## Portishead Branch Line (MetroWest Phase 1)

9.1 ExA.Sch.D3.V3 – Schedule of Changes to the draft Development Consent Order

**Log of drafting changes for Deadline 3 draft DCO**

**21 December 2020**

BRIDLEWAY EXTENSION PLAN
UNDER ELEVATED M5

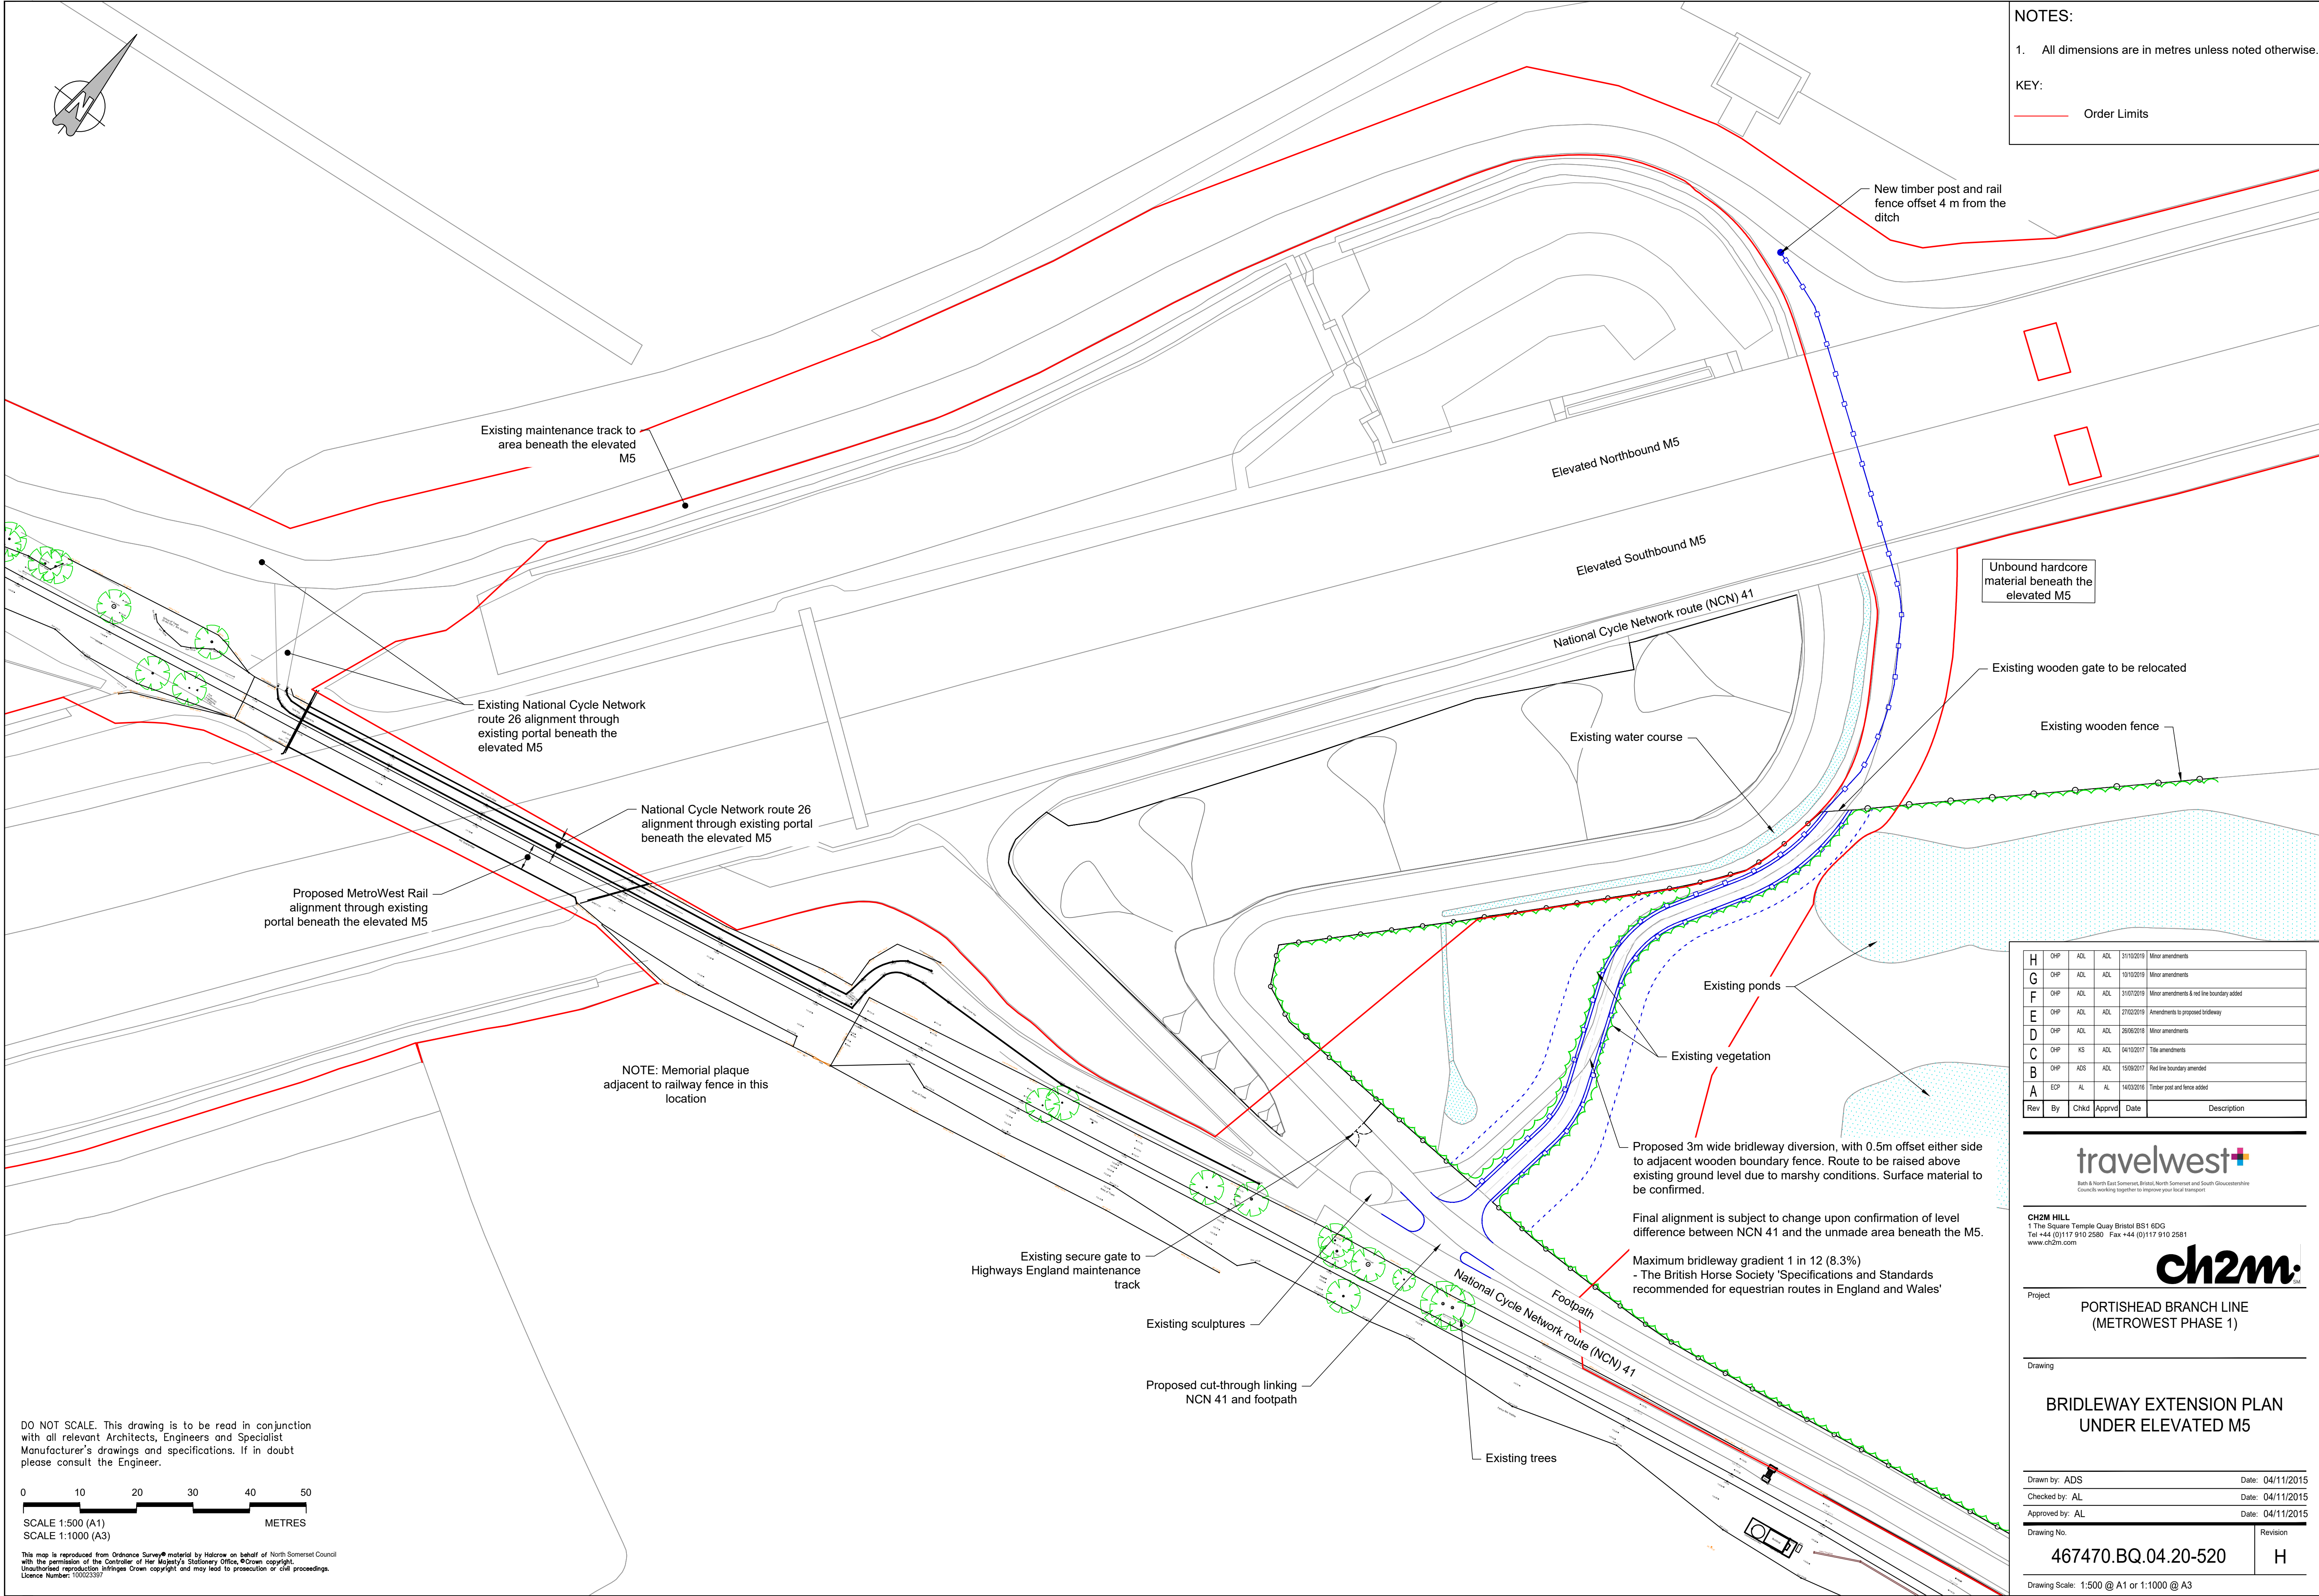
Schedule 2, Requirement 32	<p>Amended to reflect removal of Work No. 18 from requirement 4:</p> <p>32(1) Work No. 18 must not commence until the siting, design, landscaping and method of construction of the proposed bridleway have been submitted to and approved by the relevant planning authority. <b>The submitted details must adhere to the principles shown on the Bridleway Extension under the Elevated M5 Plan.</b></p> <p>(2) Work No. 18 must thereafter be carried out in accordance with the approved details.</p>	This is to avoid duplication of control between Requirement 4 and requirements specific to the relevant work.	-	See Requirements 4, 18, 32 and 33
Schedule 2, Requirement 33	<p>Amended to reflect removal of Work No. 27 from requirement 4:</p> <p>33. (1) Work No. 27 must not commence until the siting, design, and method of construction of the proposed ramp have been submitted to and approved by the relevant planning authority in consultation with the relevant</p>	This is to avoid duplication of control between Requirement 4 and requirements specific to the relevant work.	-	See Requirements 4, 18, 32 and 33

<p>highway authority. The submitted details must adhere to the principles shown on the Ashton Vale Road Pedestrian Ramp Design Plan.</p> <p>(2) Work No. 27 must thereafter be carried out in accordance with the approved details.</p>			
Schedule 17 – Documents to be Certified	Removal of number "84"	Automatic numbering had continued in error	-	-
Schedule 17 – Documents to be Certified	<p>New certified plans added:</p> <p>Ashton Vale Road and Winterstoke Road Highway Works plan</p> <p>Ashton Vale Road Pedestrian Ramp Design Plan</p> <p>Bridleway Extension Under the Elevated M5 Plan</p>	Consequential amendments arising from Works 18, 27 and 28 being removed from	-	-
